From: Amanda Scholes on behalf of Planning.Responses
Sent: 08 June 2020 11:50
To: Planning Scanning
Subject: FW: 2020-05-15-19163-PARCELS A2 & B6, Littlehampton - Drainage Drawings

Comments;

Subject: 2020-05-15-19163-PARCELS A2 & B6, Littlehampton - Drainage Drawings

© This drawing and the building works depicted are the copyright of Banners Gate Ltd and may not be reproduced or amended except by written permission. No liability will be accepted for amendments made by other persons.

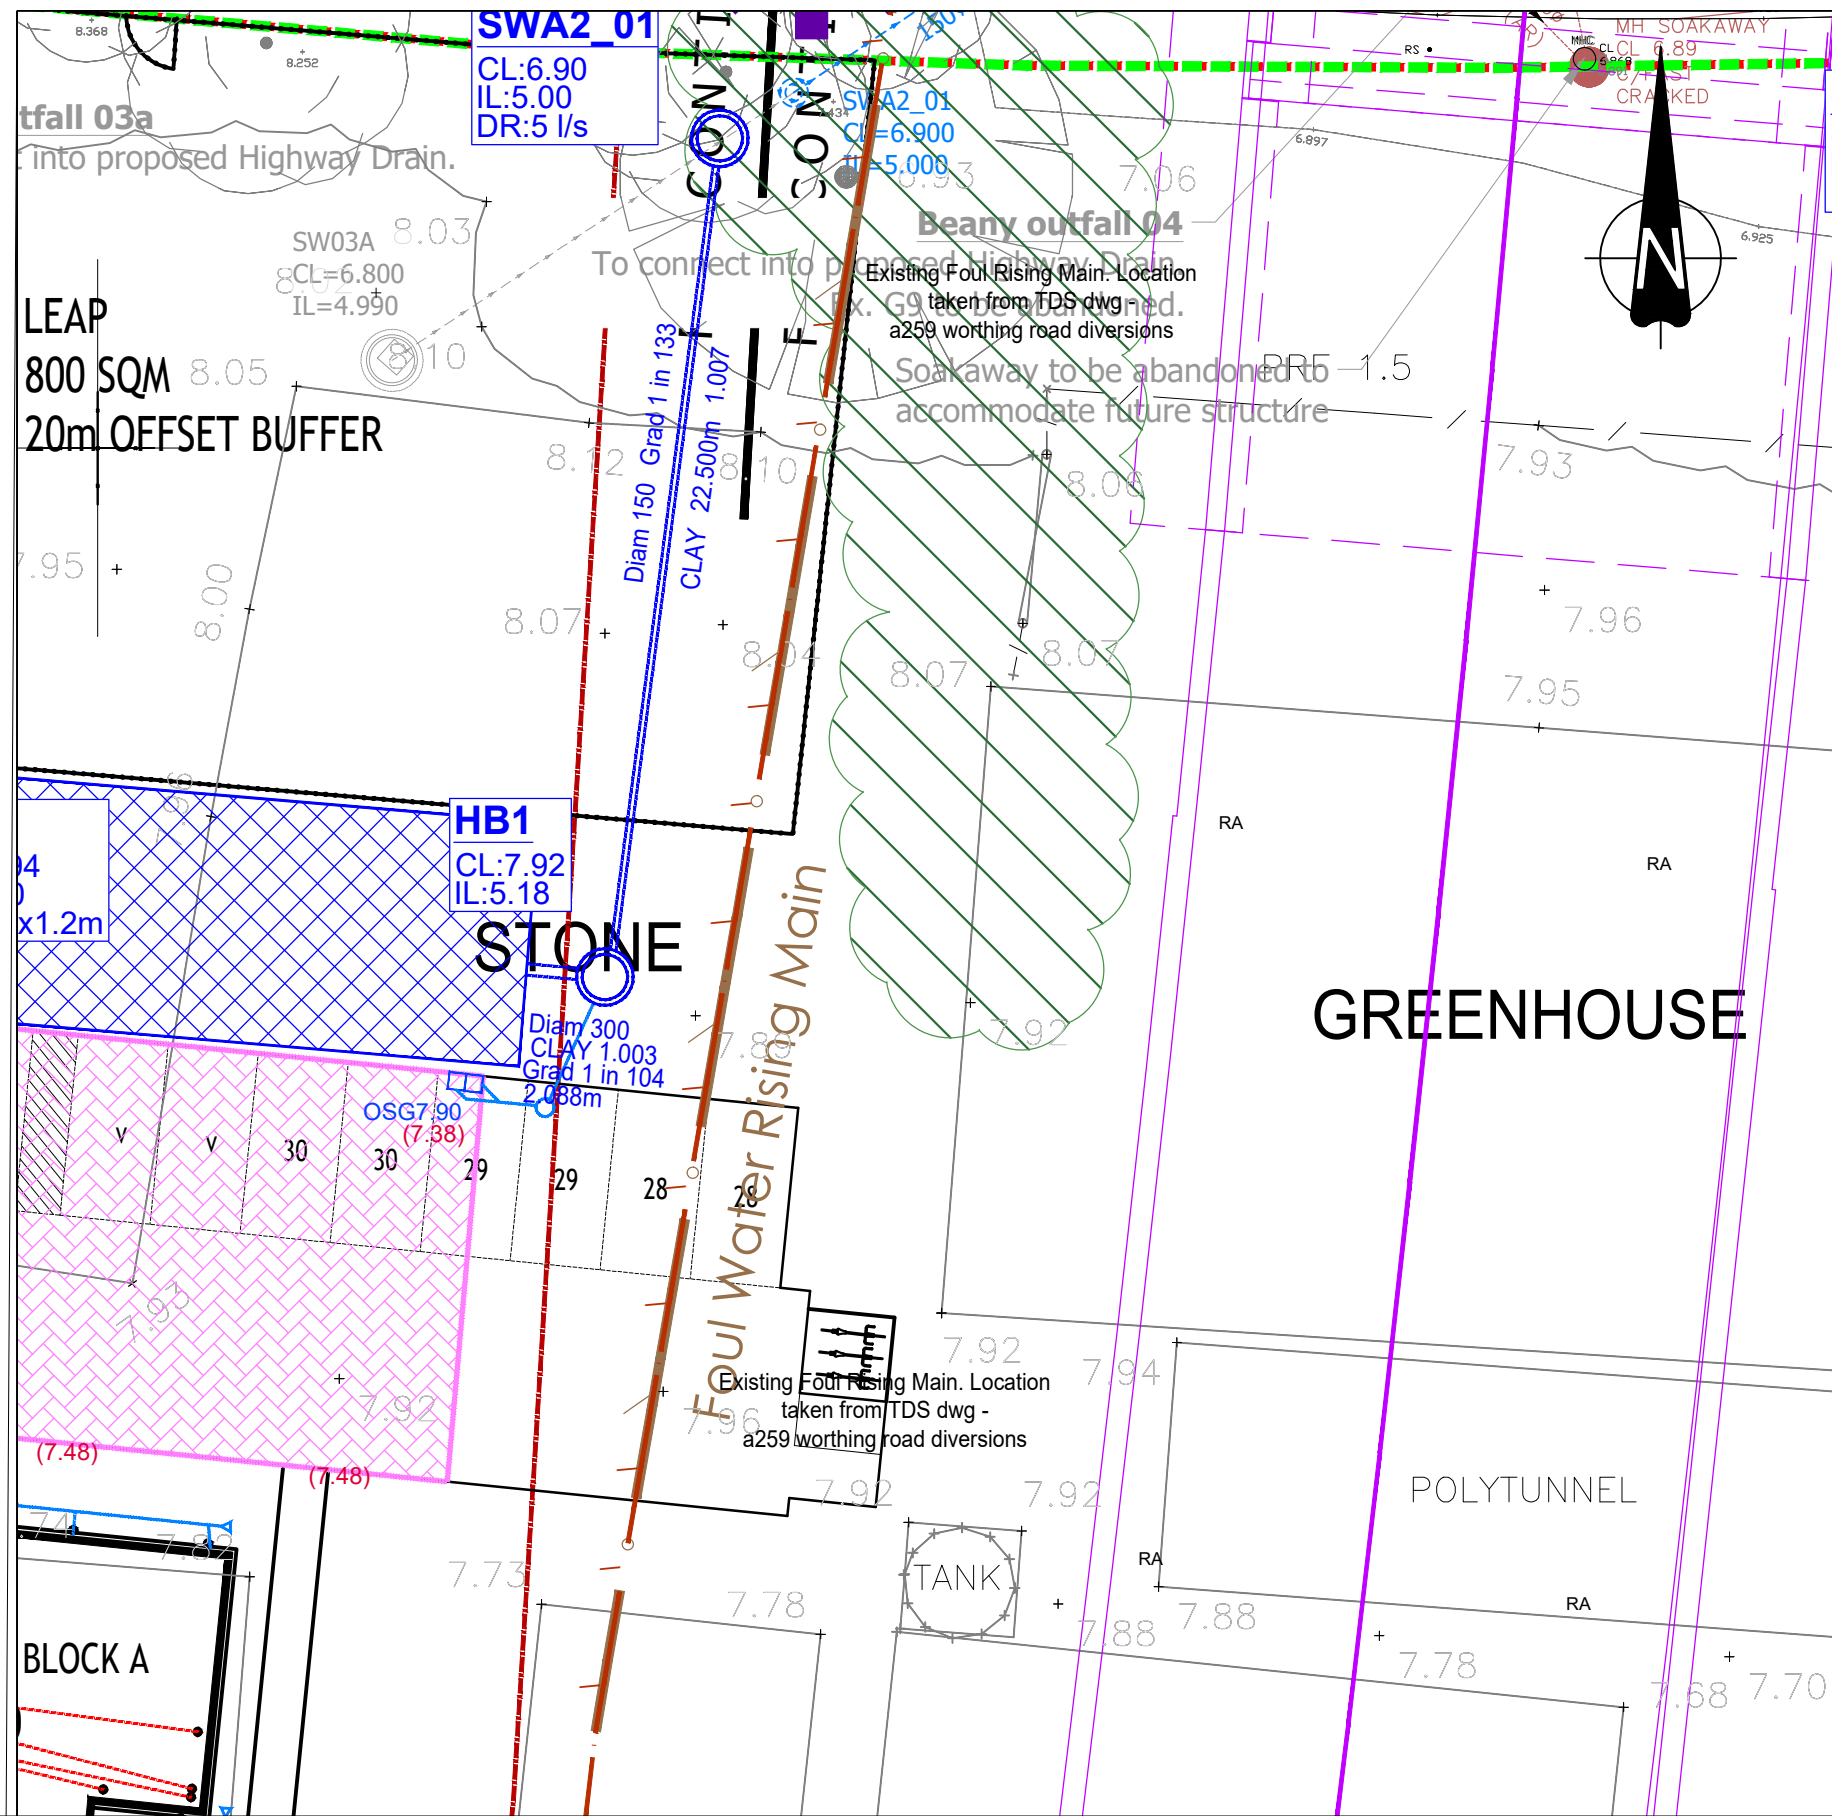
3. Provide channel drain construction details/spec. *ok*
4. Hydrobrake chamber HB01 construction detail – connect incoming 150mm connection from permeable paving at soffit to soffit level with 300mm pipe inlet. *ok*

6. Both hydrobrake chambers – show base thickness/reinforcement details. *ok*
7. Existing manhole SW03A – just upstream of SWA2_01 – what is its purpose? Invert level is lower than the downstream manhole. Please clarify if it is required and adjust as necessary. *Removed - ok*

Hydro-Brake Control Chamber HB2

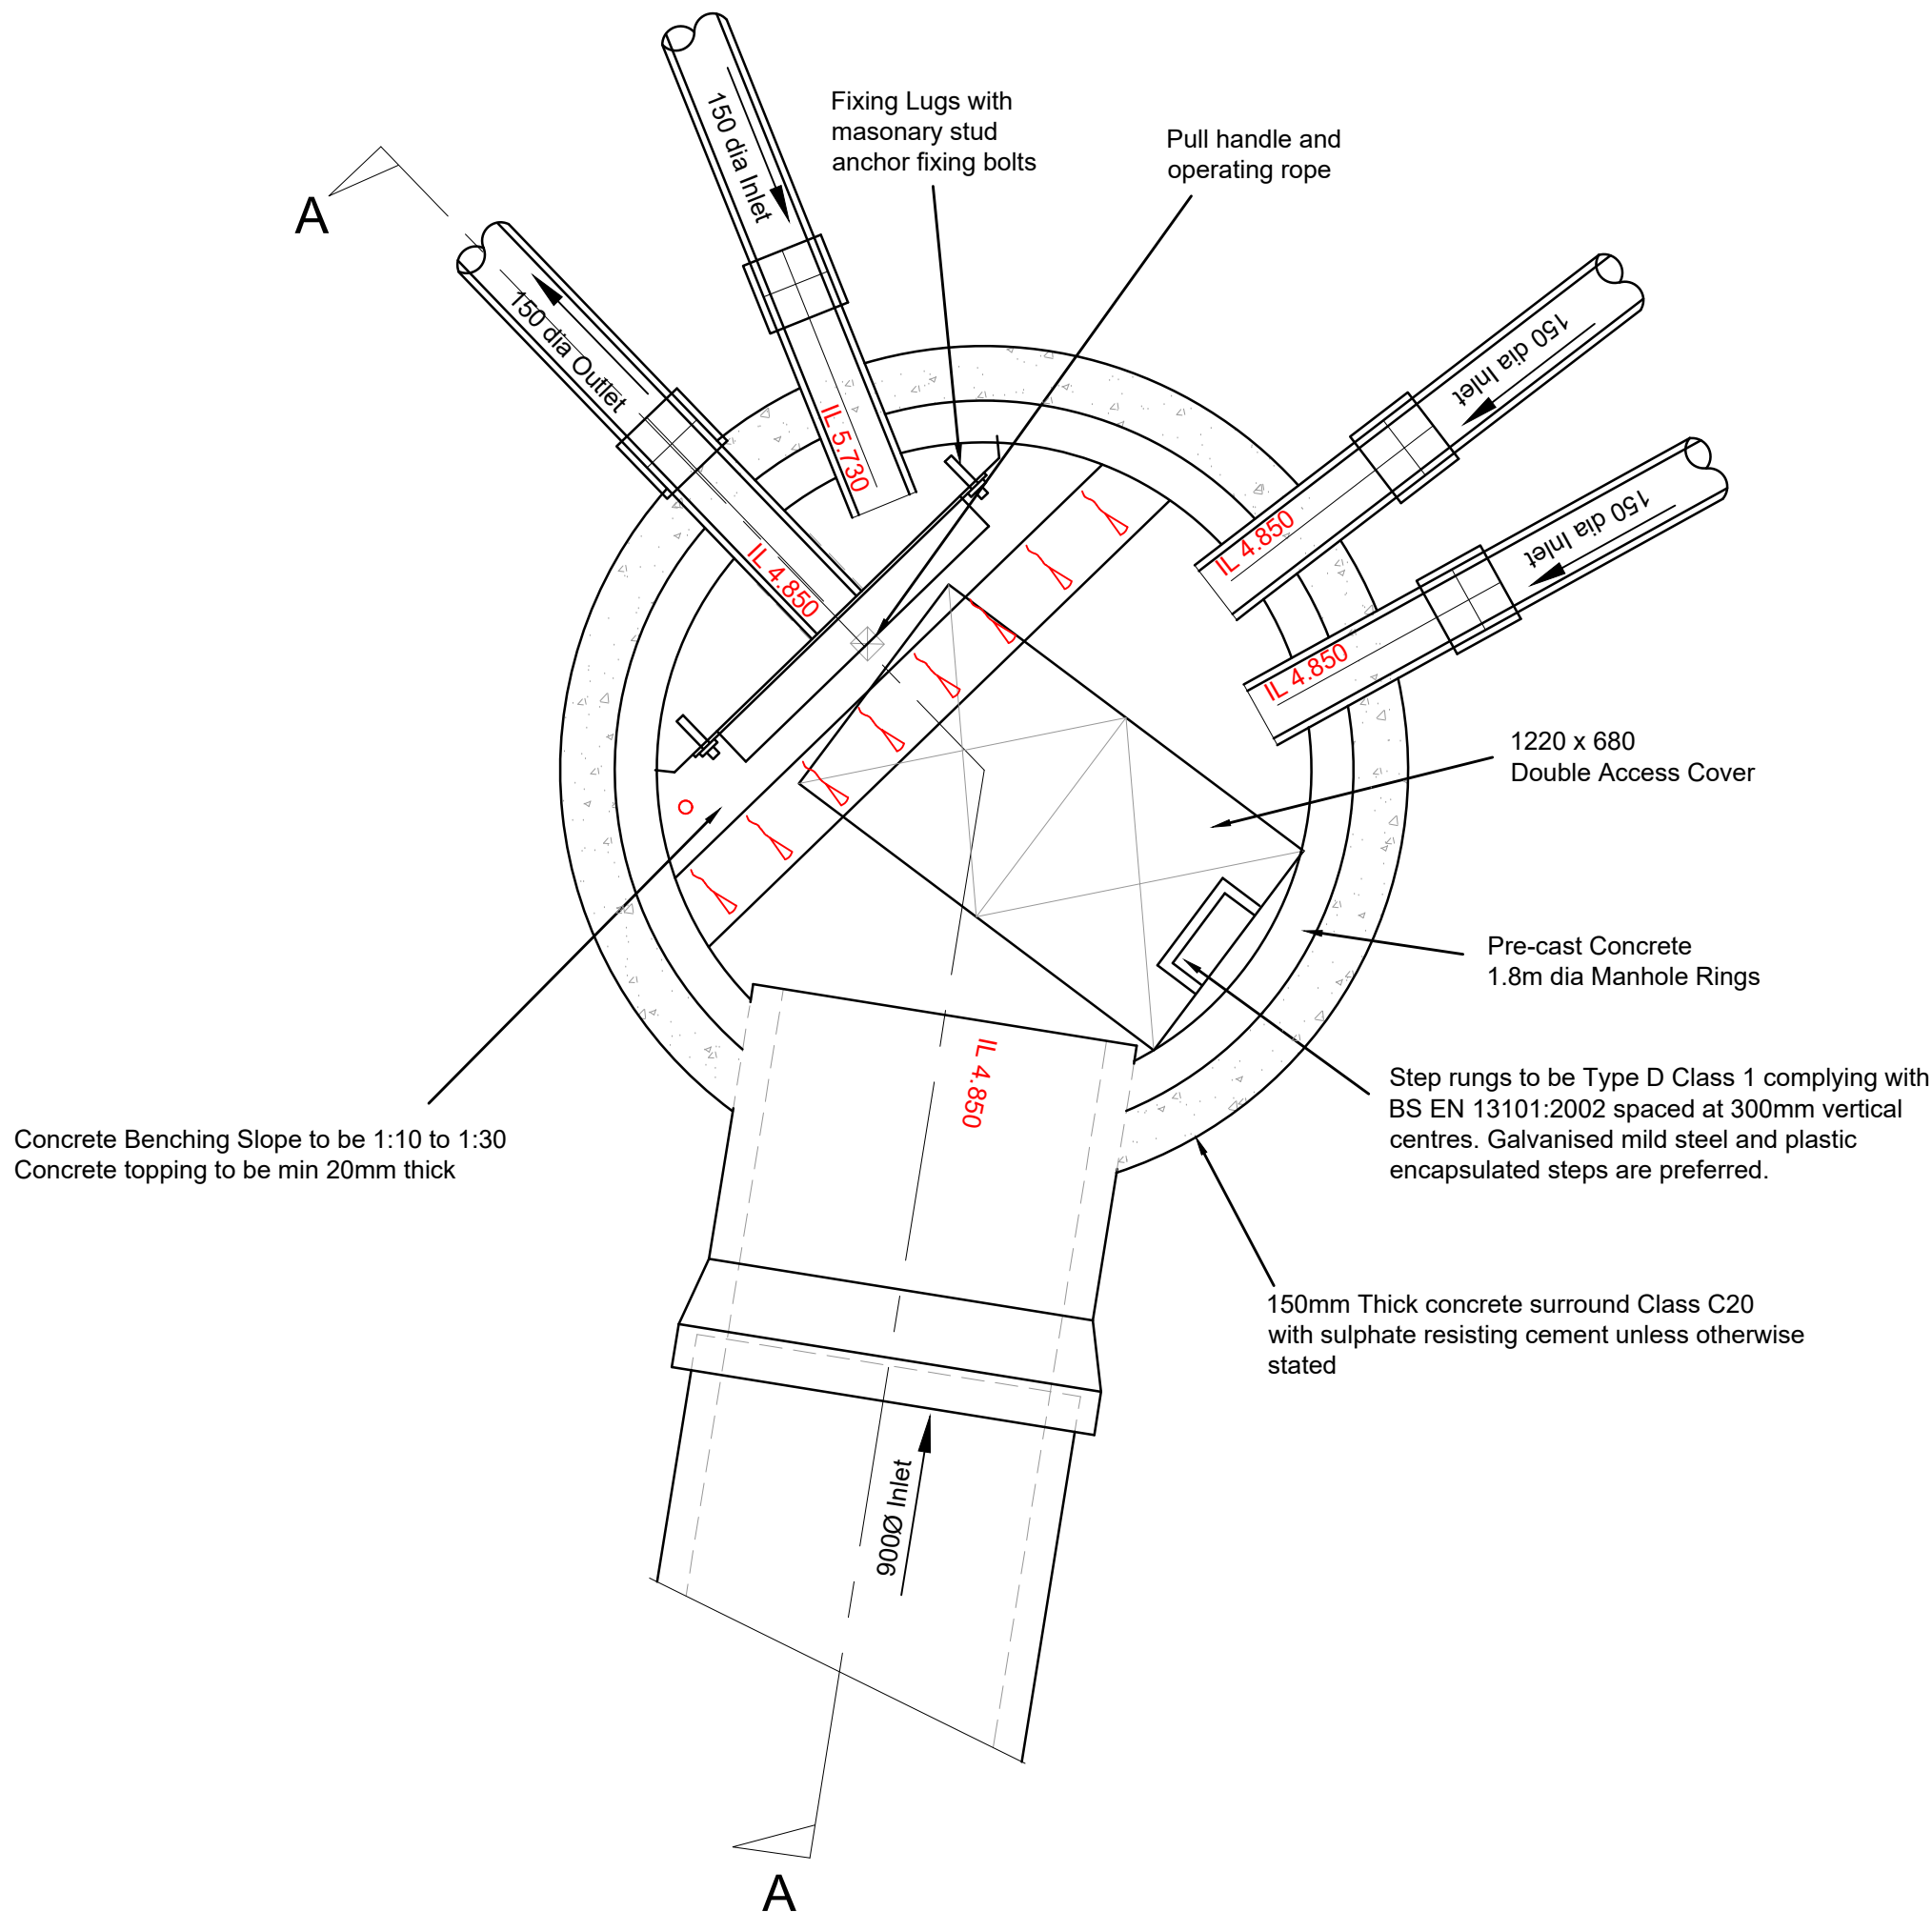
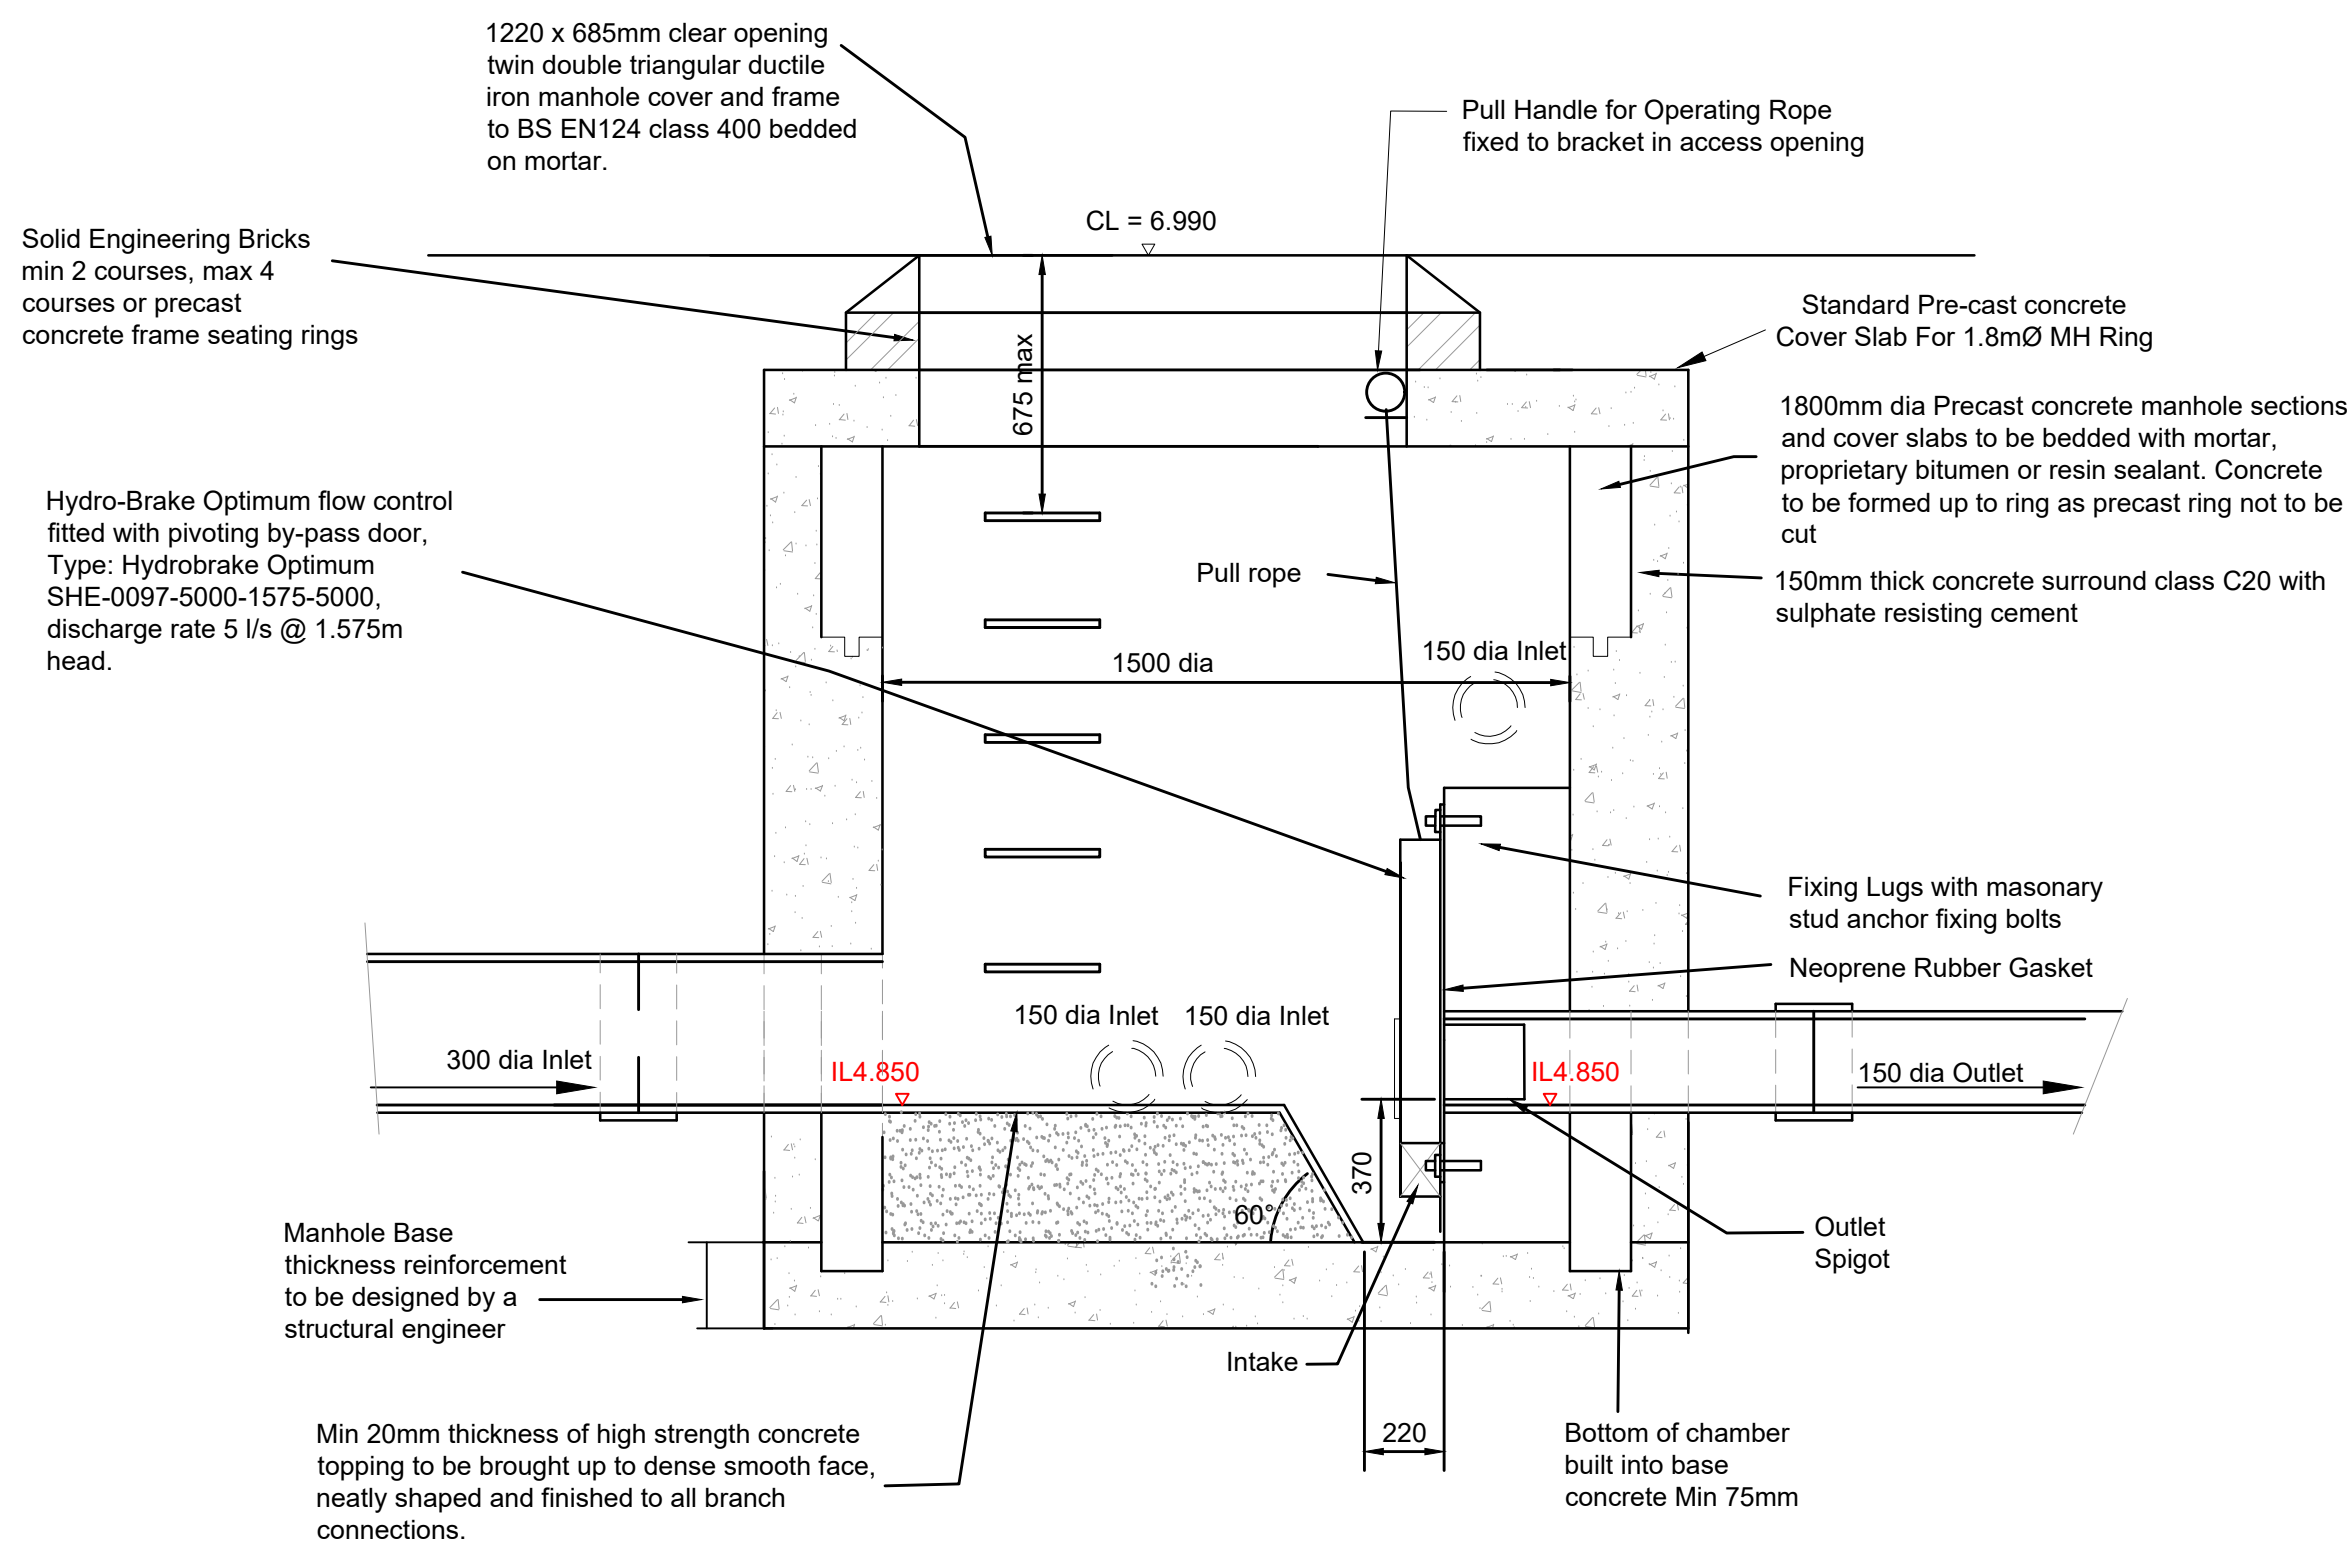
5. Hydrobrake chamber HB02 construction detail – plan view shows incoming 900mm pipe as opposed to 300mm and 1.8m dia rings as opposed to 1.5 dia. Incoming 150mm connections to connect soffit to soffit with 300mm pipe. The gully that is connecting against flow and above hydrobrake is not ideal but willing to accept it in this instance (Section A-A shows it in a different location to the plan view?) *ok*
